Cambridge Waste Water Treatment Plant Relocation Project
Anglian Water Services Limited

Applicant's Comments on Local Impact Reports

Application Document Reference: 8.11

Figure 3.19 Example: Technical drawing of a vent stack

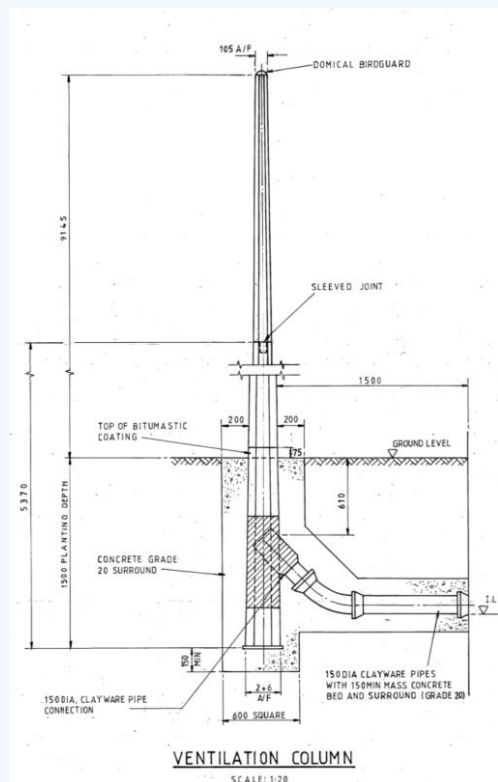
9	4 Odour impacts	<p>The Applicant notes the comments at 9.17 – 9.23, focusing on the concerns for potential impacts (“... adverse impacts on amenity / quality of life and living conditions”), further specifically detailed to be in relation to odour impacts, associated with the permanent waste water transfer tunnel ventilation stack (WWTTVS -located at Shaft 1) on the future residential development at the NEC site.</p> <ul style="list-style-type: none"> The Applicant refers to the Project Description and Tunnel drawings with references as follow: APP-026 Anglian Water Services Limited 4.12 Design Plans - Sewage Tunnel and Longitudinal Sections REP1-021 Anglian Water Services Limited 5.2.2 Chapter 2 Project Description <p>The documents detail the location and height of the proposed WWTTVS. The drawings included in the NEC AAP do not pinpoint the WWTTVS. However, the Applicant confirms that the information has been made available for development of the proposed NEC AAP layouts.</p> <ul style="list-style-type: none"> The Applicant confirms that the future NEC AAP residential receptors have been considered in the odour impact assessment. The Applicant confirms that consideration for odour modelling of the WWTTVS concluded that it would not be a suitable tool for assessing the potential impacts due to the nature of the infrequent and unpredictable use of the vent stack. The interception shaft is a design feature that requires ventilation facilities. The Applicant has now discussed with the Council (in a meeting on 29 November 2023) the purpose of these facilities to clarify their function. The purpose of the ventilation facility is to allow air into the tunnel system and passively manage air pressure, a process referred to as natural aspiration. As discussed in paragraph 3.5.2 of ES Appendix 18.4 Preliminary Odour Management Plan (App Doc Ref 5.4.18.4) [AS-106], air would enter under typical operations and exit less frequently under extreme operating conditions if and as these arise. Odour could be released via the vent stack

Reference	Topic	Applicant's Response
		<p>when air exits the tunnel system under extreme operating conditions, most likely a high rainfall event when larger quantities of waste water enter the tunnel displacing air out of the tunnel. As the process is passive, and dependent upon air pressure within the sewer, it is not possible to accurately predict frequency or duration of air released from the ventilation facility, only to acknowledge that odour could be released through the vent shafts and would be intermittent and short-lived. As odour modelling models a year's worth of information, the impact would be so insignificant that it would not be seen/visible using modelling as the tool for odour impact consideration. The Applicant has also shared images of a typical "vent stack" (in the meeting on 29 November 2023) to demonstrate that they are tall slim structures resembling lamp posts and do not have the visual intrusion previously envisaged.</p> <ul style="list-style-type: none"> • The Applicant would recommend a 15m separation buffer or 'cordon sanitaire' to the closest houses from vent stacks. Vent stacks already exist in the Cambridge catchment – similar in appearance to lamp posts, and can be located on streets or green spaces. • The applicant has not in the past had concerns associated with insufficient dispersion and dilution at high level with vent stacks of 10m height. However, consideration to maintain airflow around vents stacks would remain a requirement.
